Recommendation Report for Planning Permission for Works or Extension to a Dwelling

REF NO: A/71/21/HH

LOCATION: Rond Point
Ham Manor Way
Angmering
BN16 4JQ

PROPOSAL: Erection of new fence adjacent to front boundary.

Elevation from Ham Manor Way (1:100)

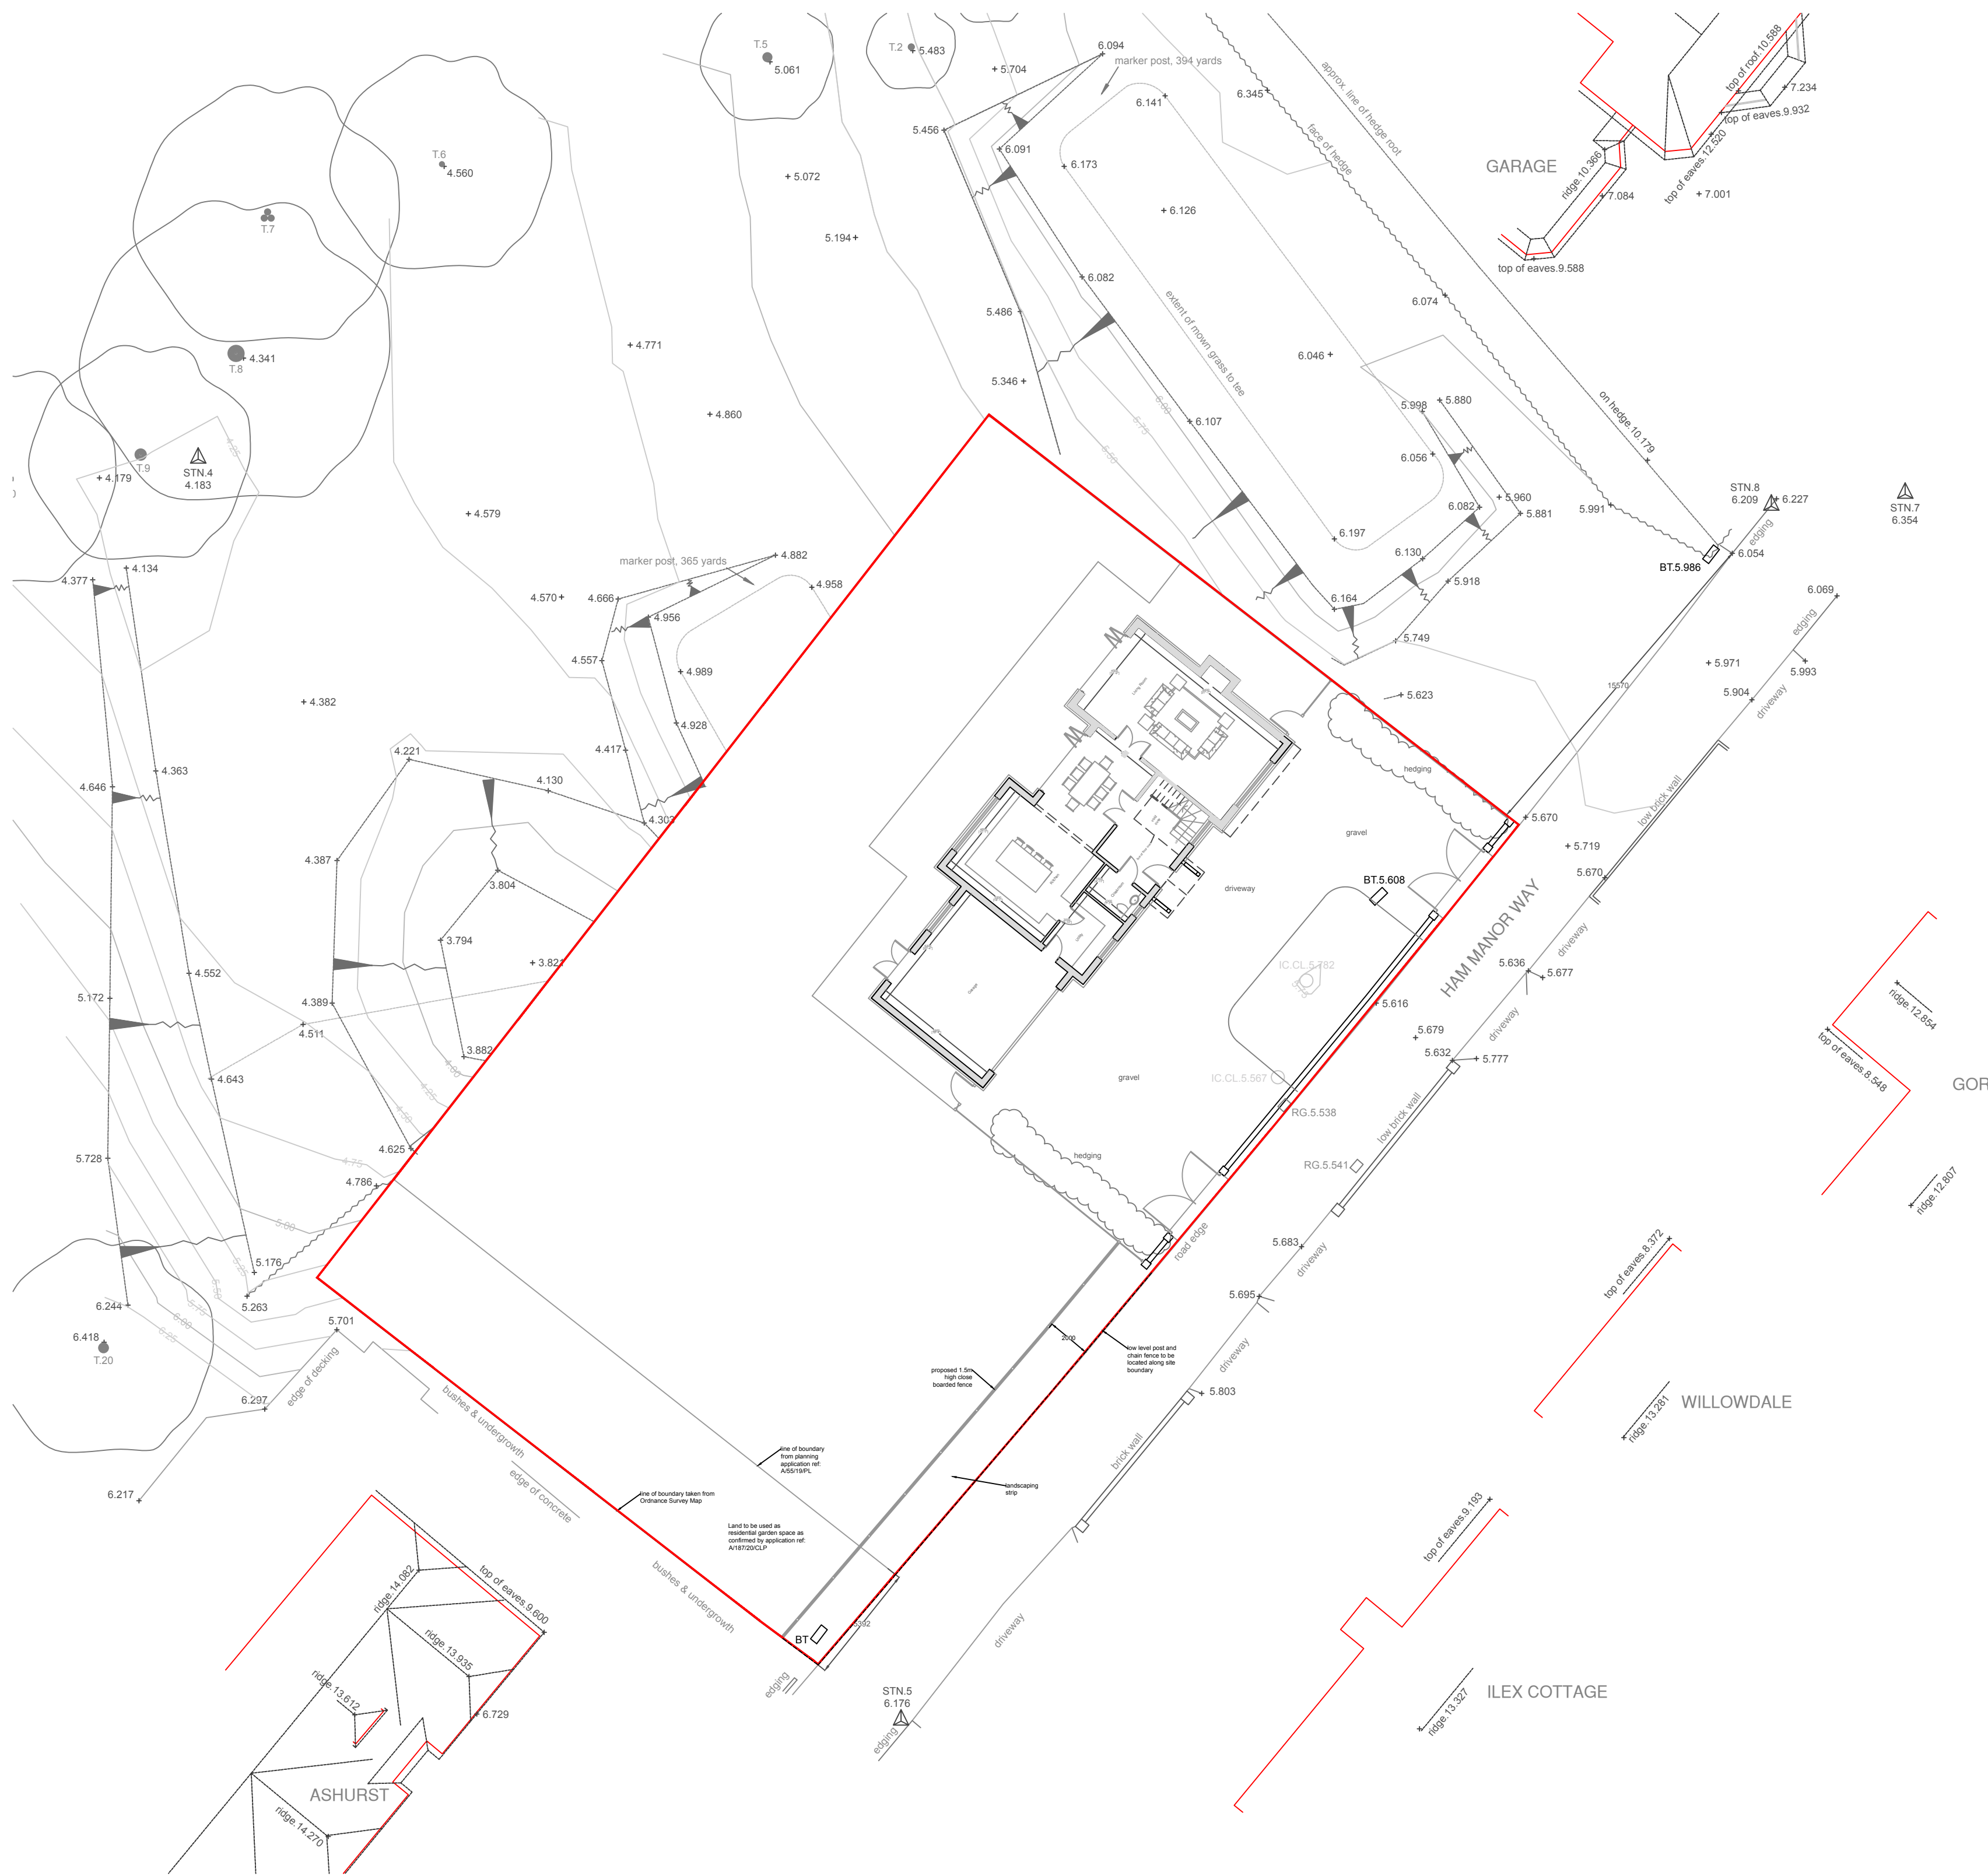
The fence would be 2m away from the highway edge with a planting buffer similar to other properties in the road. The Parish Council objected stating that the portion of road has an open feel. It is agreed that the view looking north west along Ham Manor Way, with glimpses of the golf course and further on, are very open. Many of the properties have larger planting verges than is proposed.

The fence will be incongruent appearing unduly dominant in the street scene and disrupt the open character of the locality in conflict with policies D DM1 of the Arun Local Plan and policy HD5 of the Angmering Neighbourhood Plan.

- 1 The development has a harmful impact upon the character of the street scene and the wider locality due to its harsh, dominant appearance and significant scale and height. The development conflicts with D DM1 of the Arun Local Plan and Policy HD5 of the Angmering Neighbourhood Development Plan.
